From: [REDACTED]
To: [A303 Stonehenge](#)
Cc: [REDACTED] [A303Stonehenge](#)
Subject: Stonehenge A303 ISH on draft DCO and OEMP Written submission following oral presentation given on 30 August 2019 [Ref 20017562]
Date: 03 September 2019 11:52:07

From Myra Bennett, British Horse Society Wiltshire County Access Officer (Ref 20017562)

Drawing Title
**RIGHTS OF WAY AND ACCESS PLANS
REGULATION 5(2)(k) & 5(2)(o)
SHEET 4 OF 15**

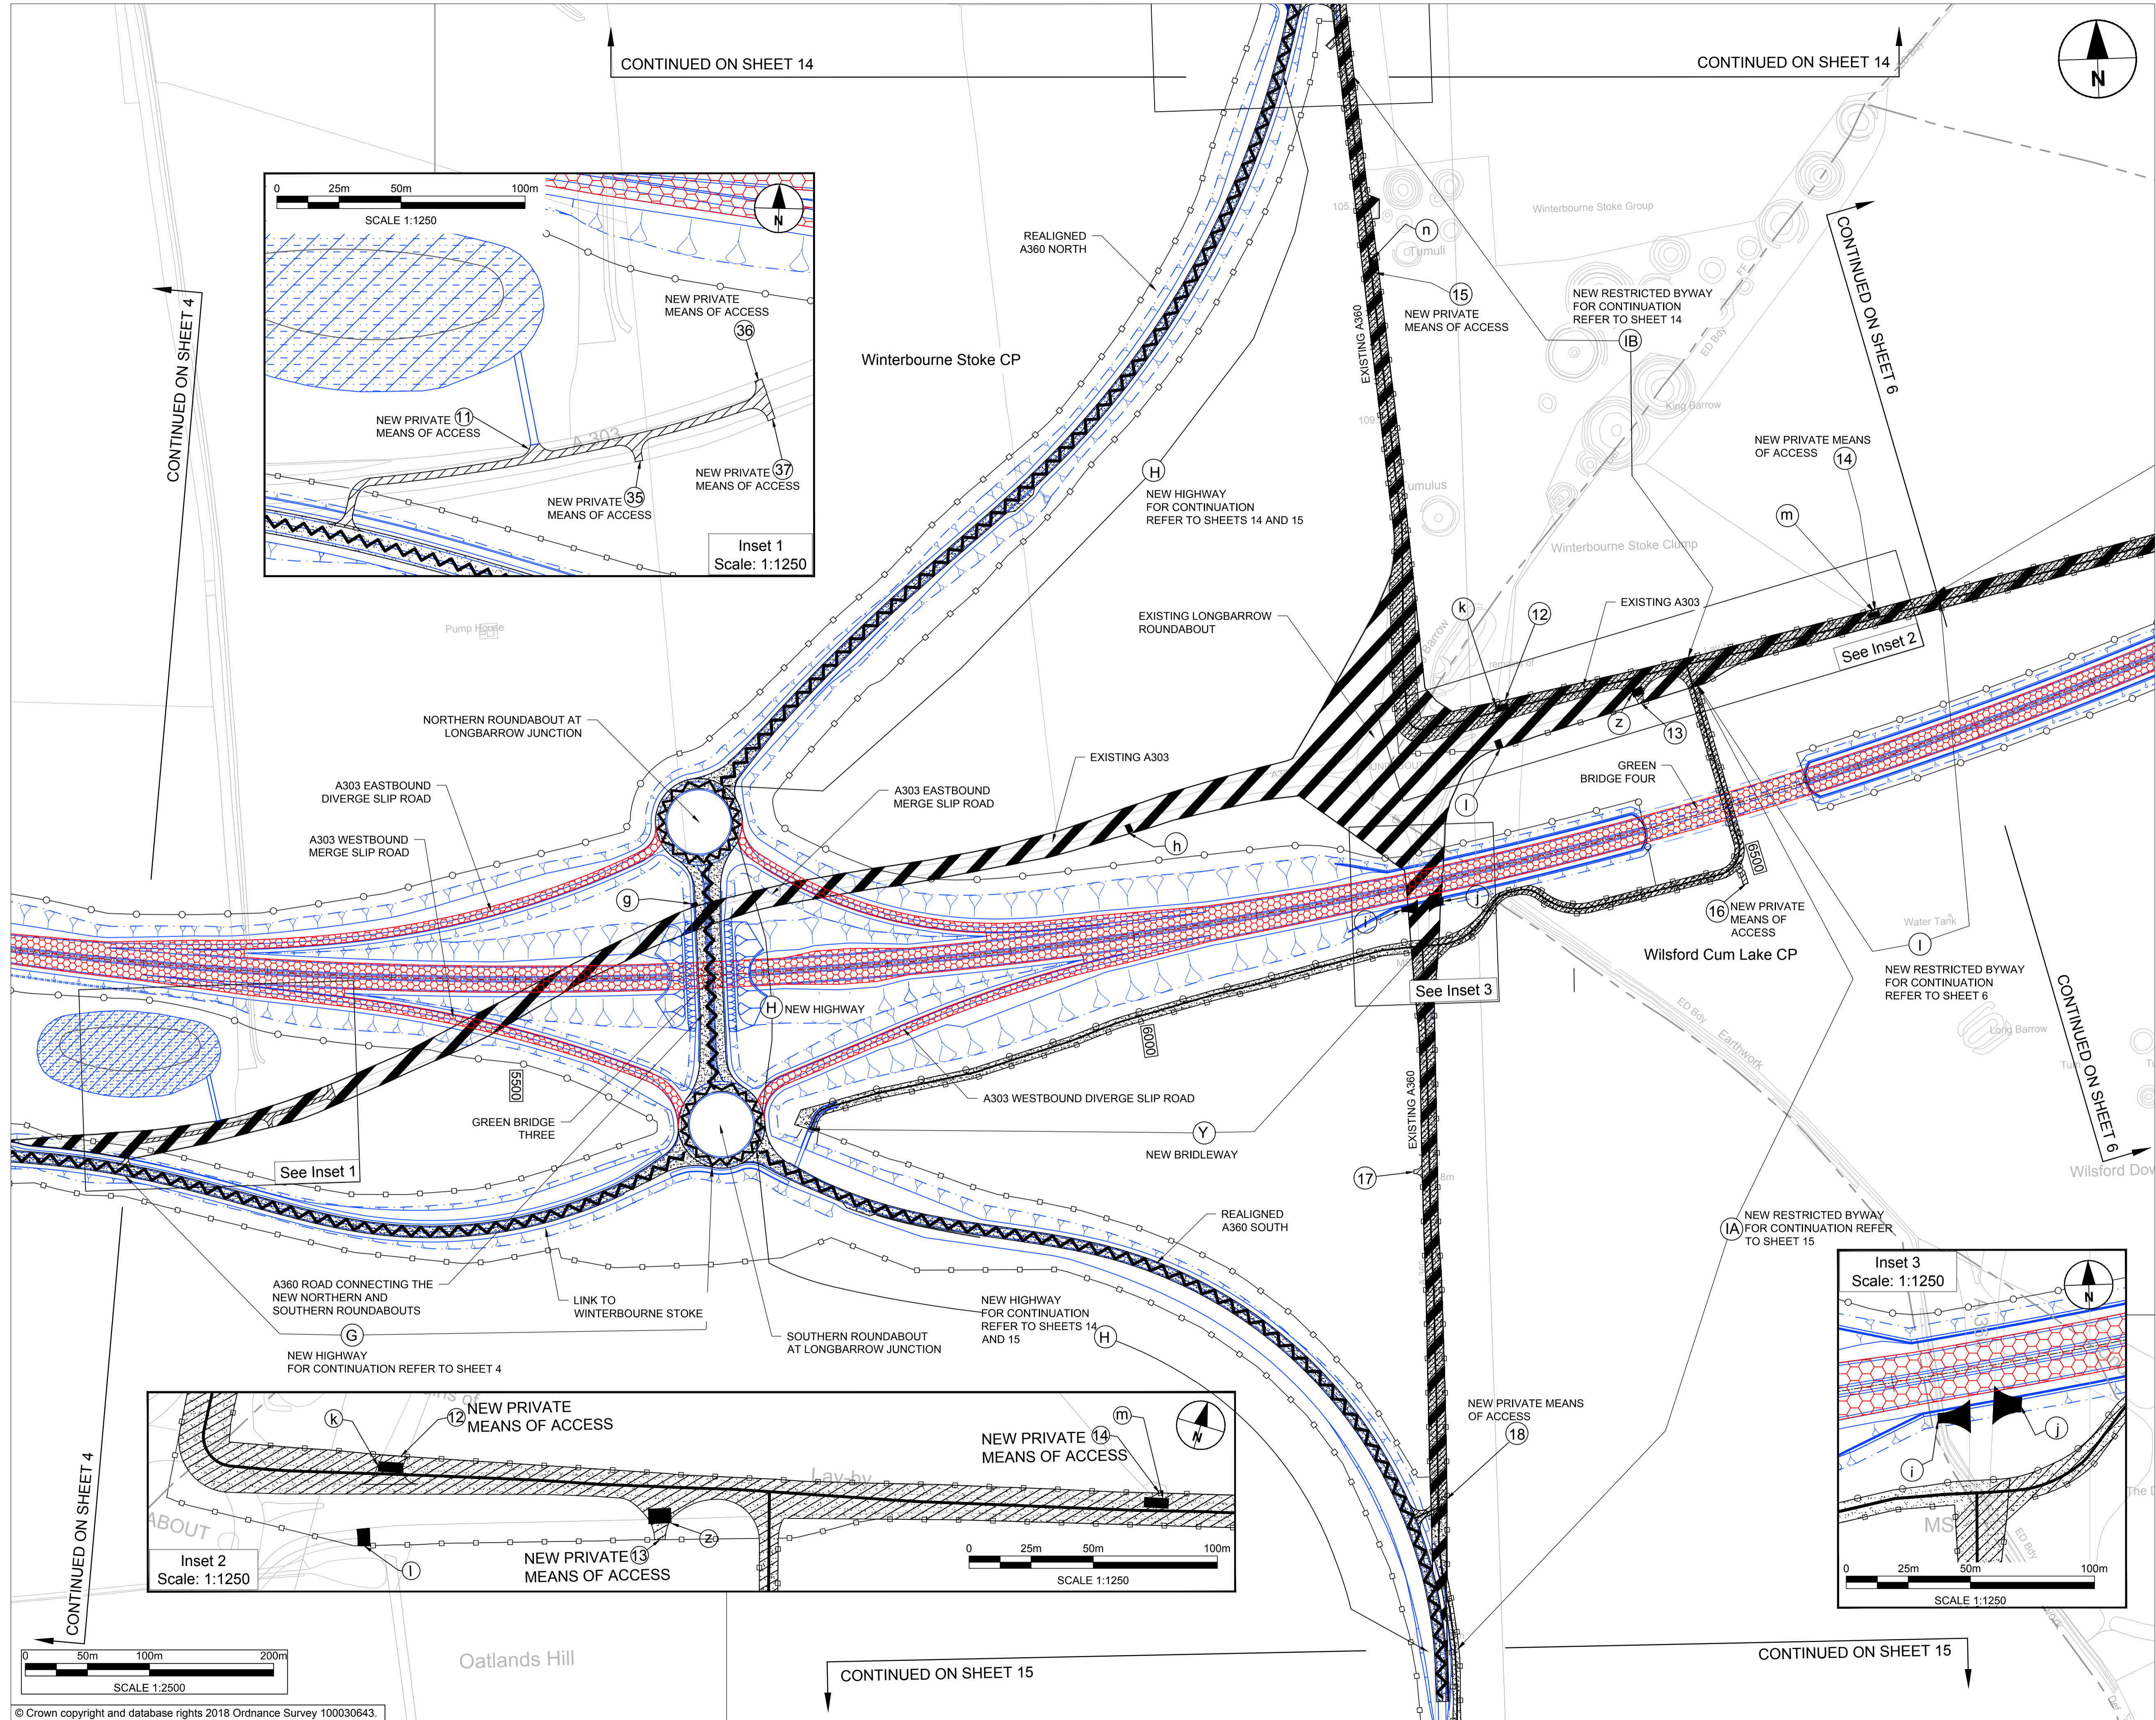
1 The Cycleway (shown on the TRO10025 - 2.9 General Arrangement Drawings Sheet 4 and 5) between the end of Bridleway Z (TRO10025 – 2.6 Rights of Way and Access Plans sheet 4) east of Green Bridge 2 parallel to the old A303 out of Winterbourne Stoke and Bridleway Y (Ibid sheet 5) beginning just east of the new Longbarrow roundabout was originally designated as a Bridleway (see TRO00025-334-6-2 26 October 2018).

I submit that entire length of the route Bridleway Z, Cycleway out of Winterbourne Stoke, round the new Longbarrow roundabout and on east over Bridleway Z must retain the designation Bridleway.

Heather Price of Highways England informed me in an email dated 27 August 2019 that ‘In summary, the connection between the Z and Y sections of the proposed bridleway [see the Rights of Way and Access Plans TRO10025-2.6 sheets 4 and 5] would be via the intervening highway verge parallel with the proposed shared use cycleways – the details are more easily seen on the General Arrangement Drawings (sheets 4 and 5 of the document APP-012 in the examination library)’. Also that ‘In our response to agenda item 4.6 [ISH 13.6.19] we clarify that [...] there is sufficient room within the new highway boundary to facilitate allowing equestrians to use the (highway) verge parallel with the shared use cycleway to Longbarrow junction.’

If this is the case, then the highway verge, as well as the width of the currently proposed Cycleway, can and must be dedicated on the DCO as a Bridleway. It is not sufficient to ‘facilitate’ or allow equestrian use, the DCO needs to provide for a Bridleway where equestrians are expected to pass and repass.

Drawing Title
**GENERAL ARRANGEMENT
DRAWINGS
REGULATION 5(2)(o)
SHEET 4 OF 15**

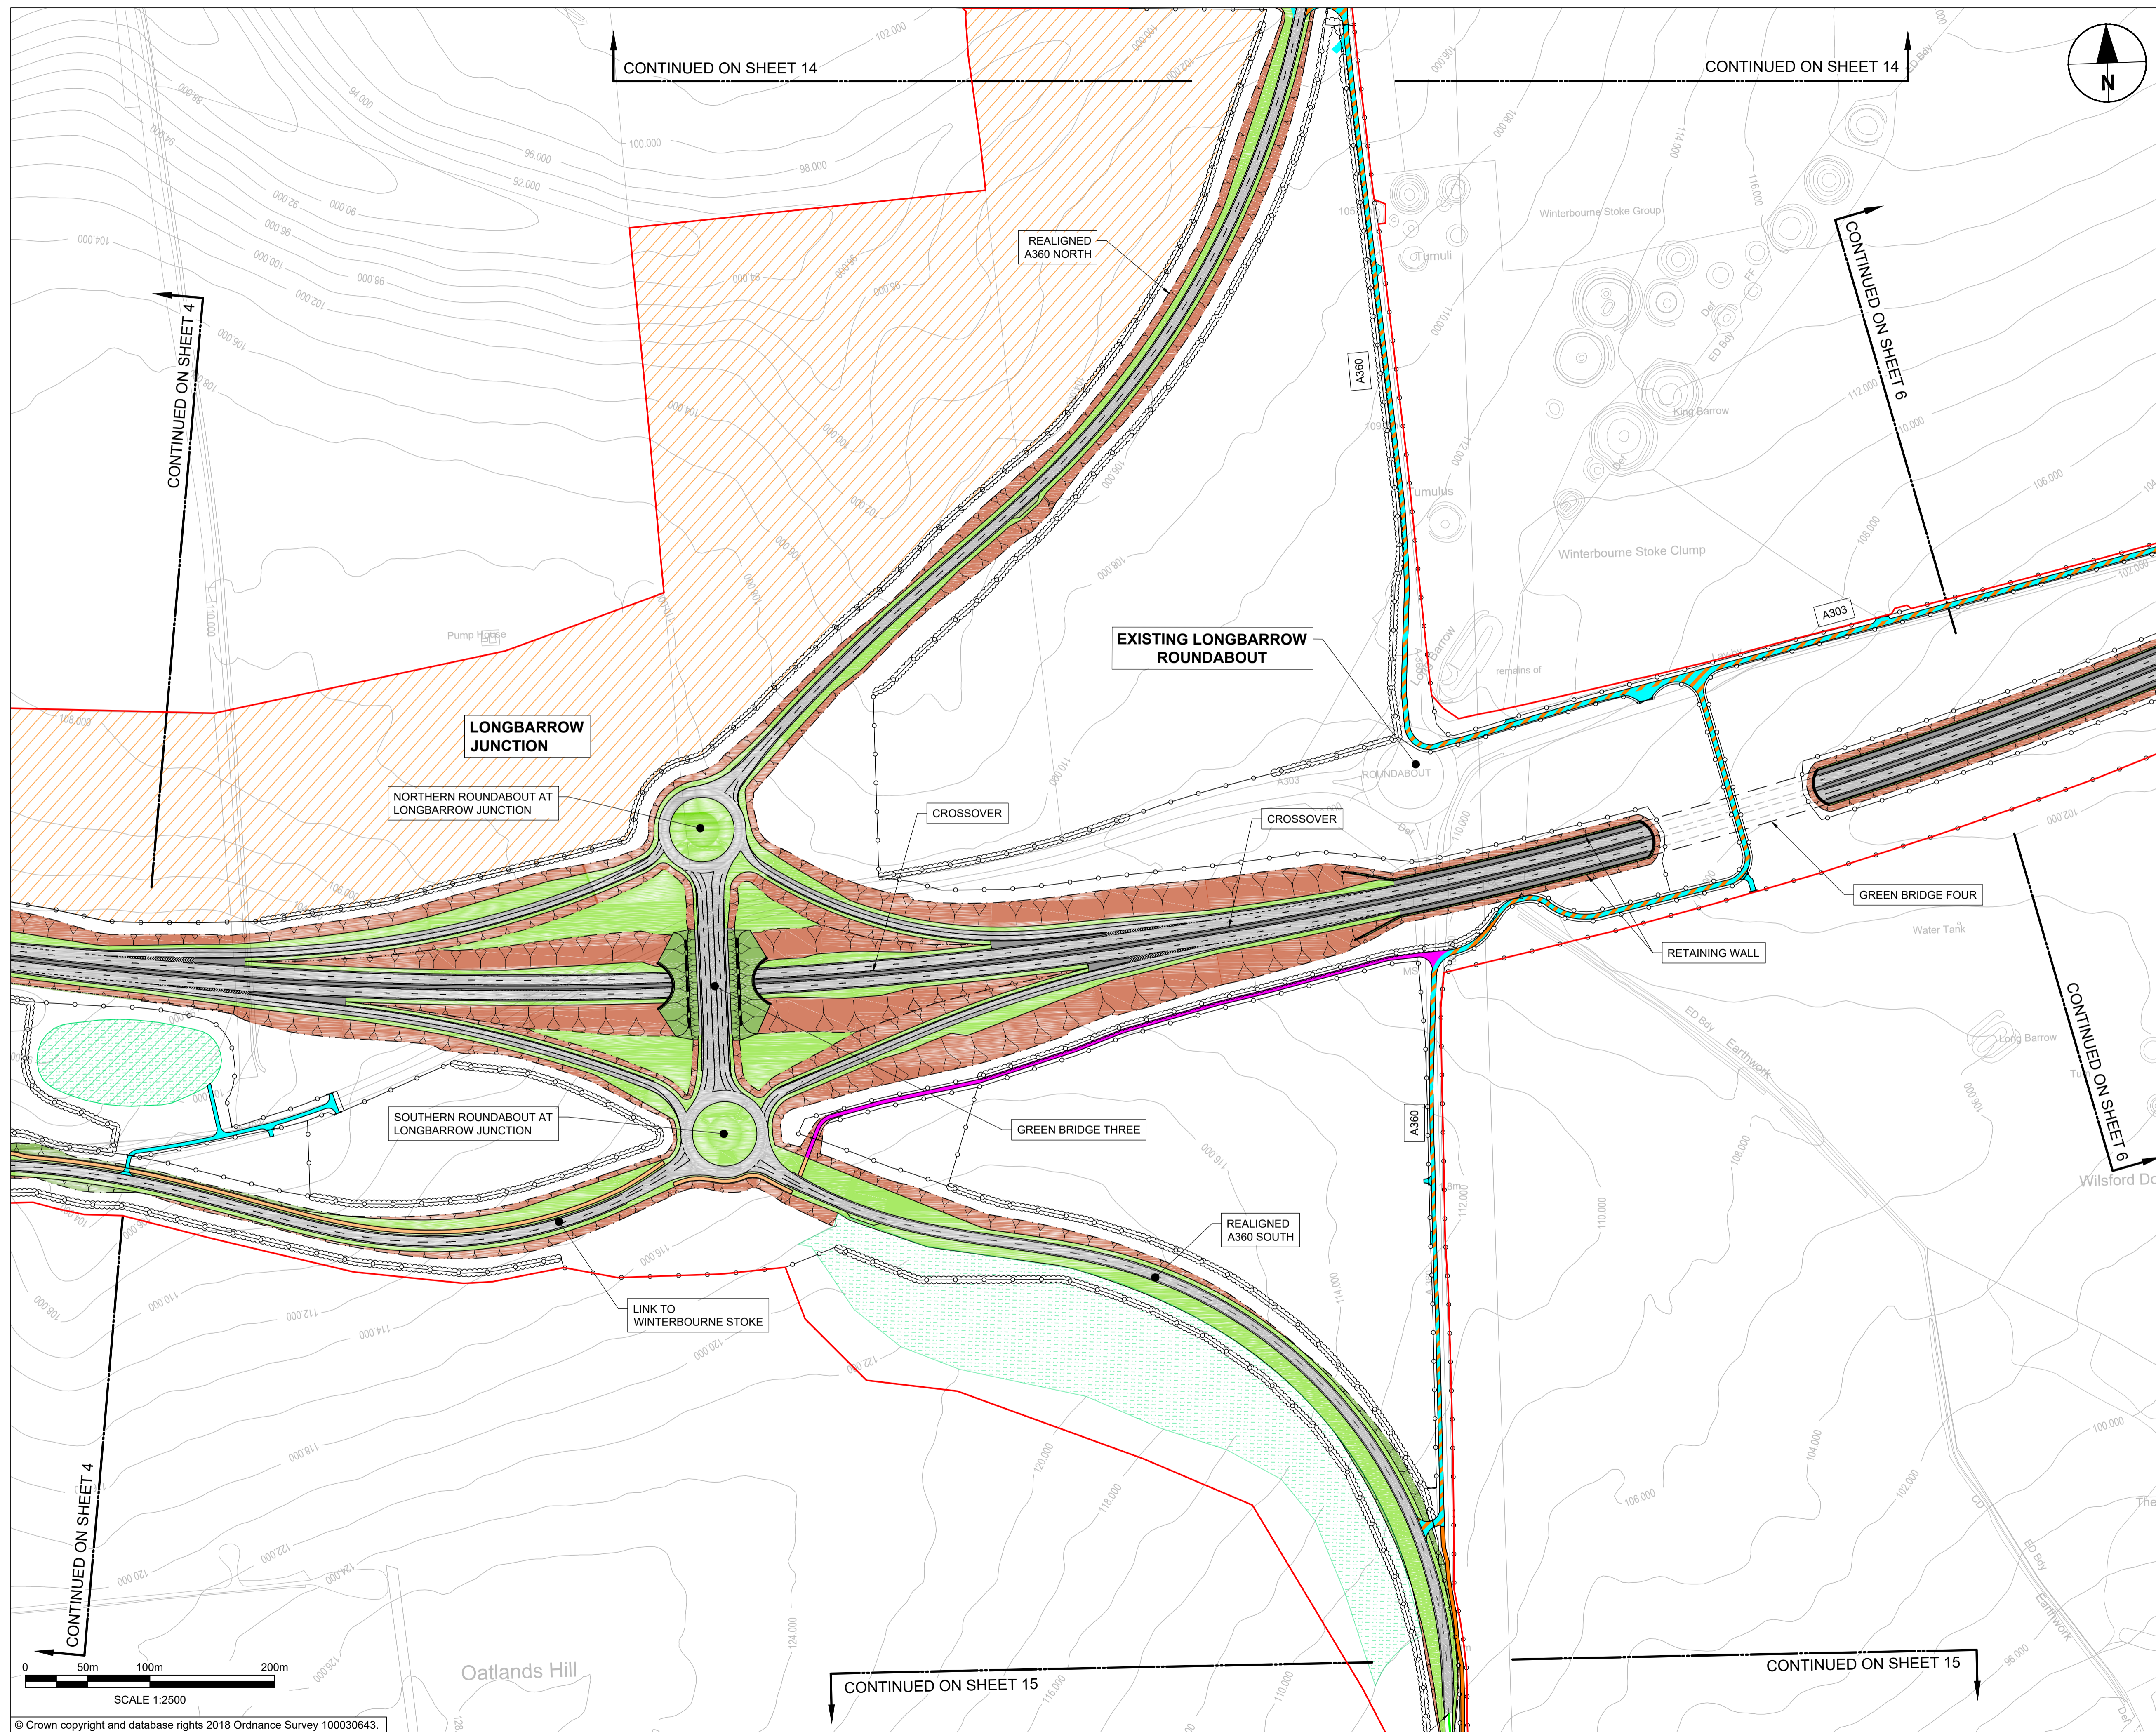
In the Written Summaries of oral submissions put at the Traffic and Transport ISH hearing on 13 June 2019 (REP 034 agenda item 4.6) Highways England explains that over the sections of the originally proposed Bridleway route parallel to the old A303 into Winterbourne Stoke, (now shown as brown Cycleway on the General Arrangement Drawings sheets 4 and 5), there ‘is insufficient width between the existing hedge and edge of carriageway to accommodate a shared use route suitable for pedestrians, cyclists and equestrians. While the existing A303 carriageway could be reduced in width by up to a metre to reflect its change in status, this would still not provide sufficient width.’ It goes on to explain this lack of ‘sufficient width’ by noting that ‘for routes used by equestrians the separation of the route from the carriageway should be a preferred minimum of 1.8m (Cl.

7.23) which would not be able to be provided at this location.’ It seems to be for this reason alone that HE have decided to use the designation Cycleway rather than Bridleway in this location.

However, the route in question is still to be provided for equestrians as a ‘shared use route’ even where the ‘preferred minimum’ distance from the carriageway is less than 1.8 metres. If horse riders are expected to pass over this length of right of way as part of their rights over the Cycleway, there is no reason why it cannot be designated as a Bridleway – the minimum separation distance is a ‘preferred’ rather than a mandatory guide. It is moreover unclear how long the affected section of route is; Highways England state that there is an intervening highway verge which equestrians could be ‘allowed’ to use *parallel* with the proposed shared use Cycleway, see below.
